CHARLOTTE - MECKLENBURG
PLANNING COMMISSION

DATE: May 29, 2001

SUBJECT: Administrative Approval for Petition No. 86-34 by John Crosland.

SITE PLAN

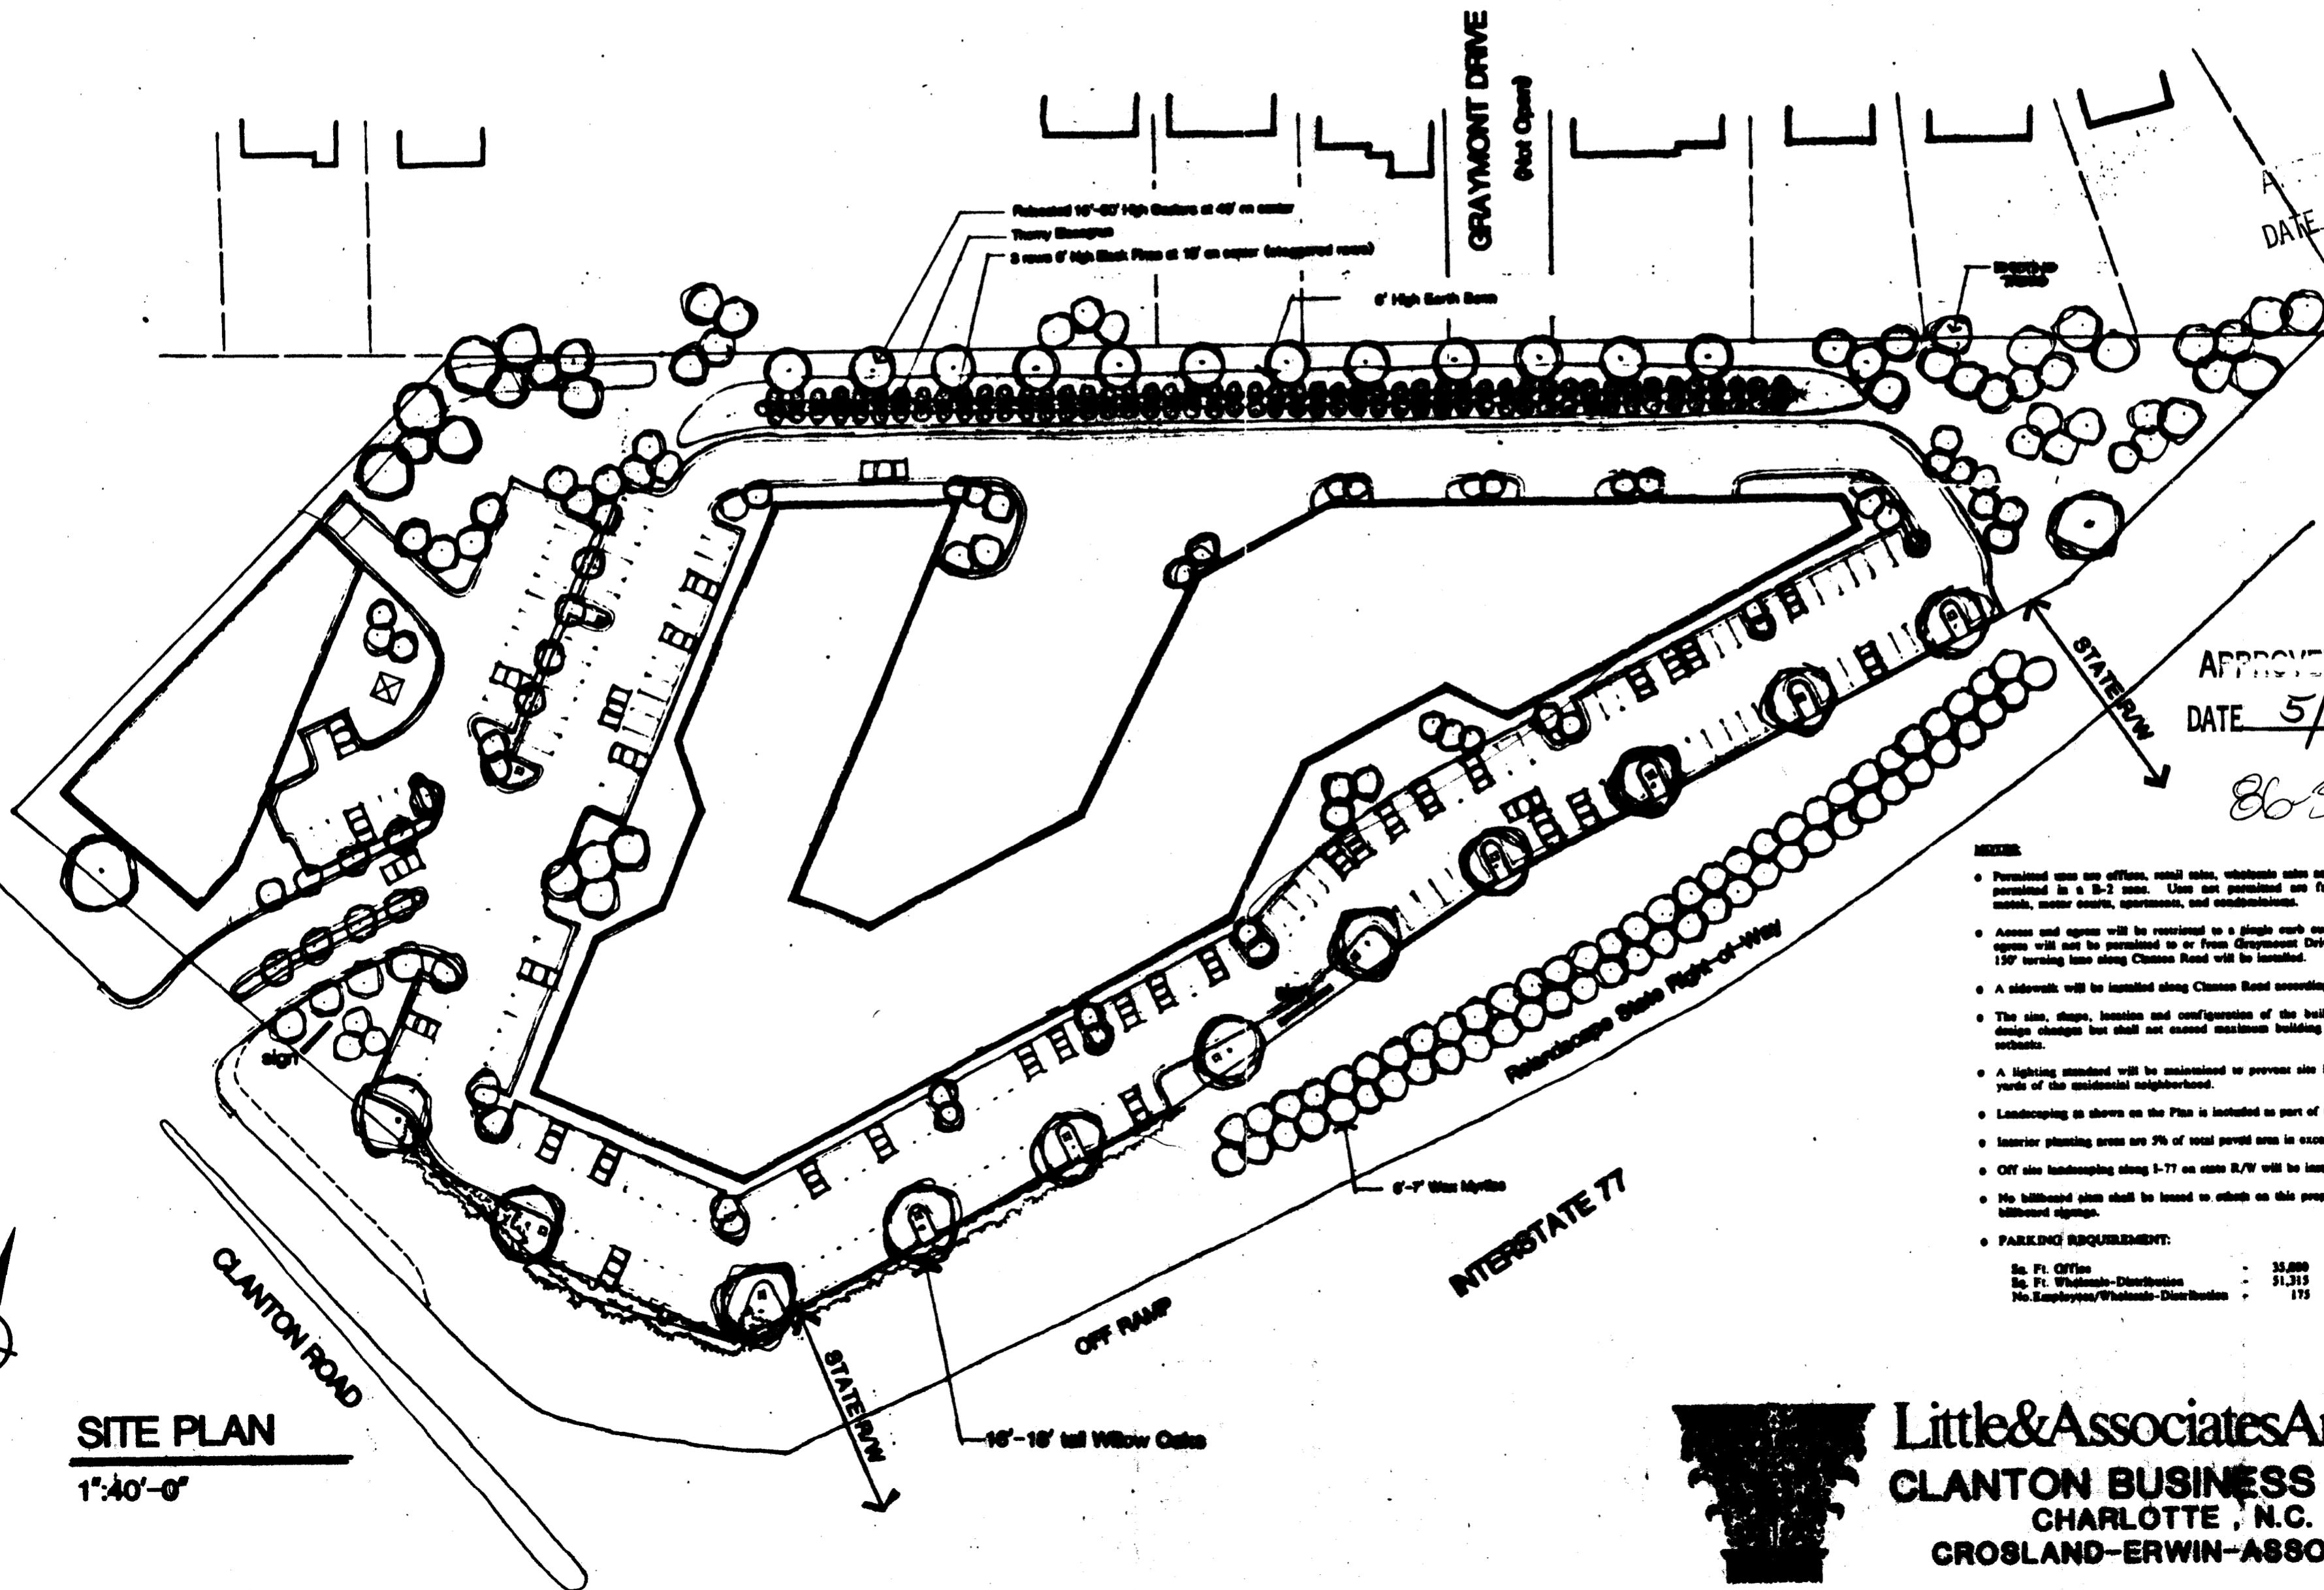
Attached is a revised plan for the above rezoning petition. The plan has been revised to clarify that residential condominiums are an excluded use. Since this clarification does not alter the intent of the original site plan, I am administratively approving this revised plan. Please use this revised plan when evaluating request for building permits and certificates of occupancy.
